Consultation Response from KC,
Lead Local Flood Authority

2025/90508 Lubrizol Ltd, Syngenta Ltd, Leeds Road, Huddersfield, HD2 1FE

Erection of canopy to existing yard and extension to existing external storage yard

Date Responded: 6th June 2025

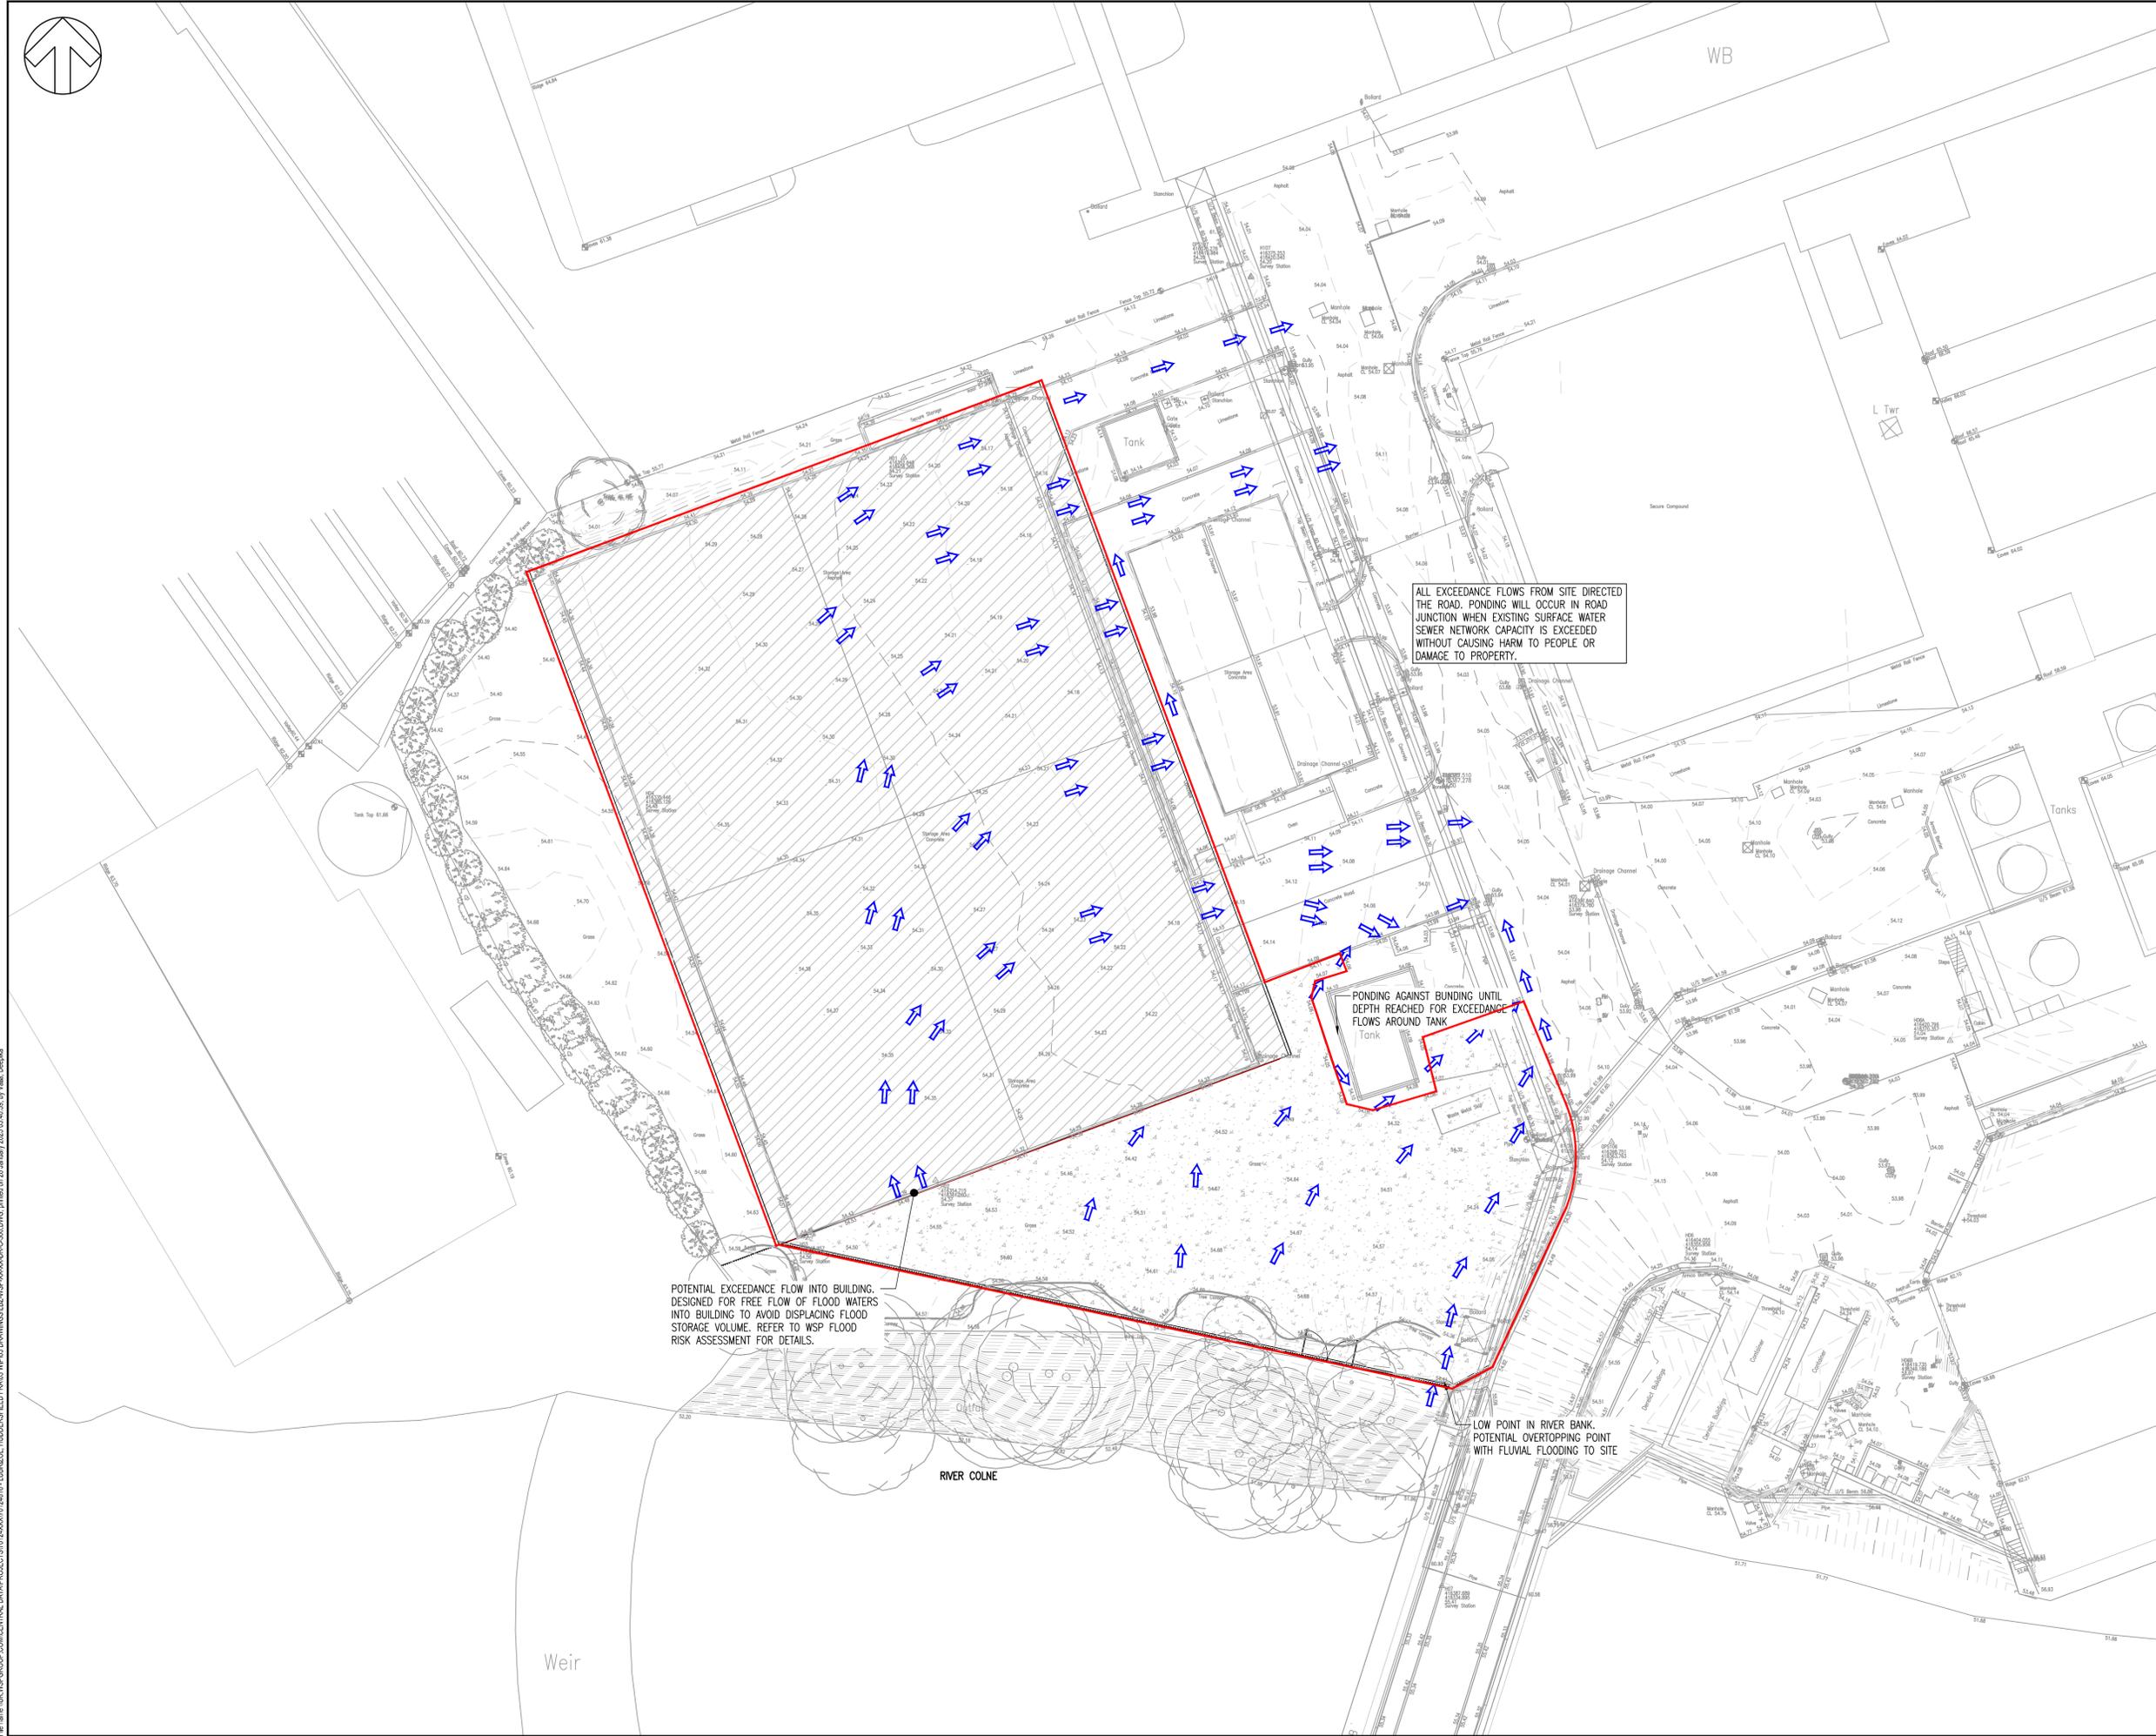
Kirklees accepts a 30% reduction on peak discharges from this development to similar points of connection on the same system. It appears this has been calculated as part of the submitted FRA.

However it then indicates a free discharge from the canopy roof and attenuated from the new impermeable parking area.

All flows should be attenuated to the agreed rate.
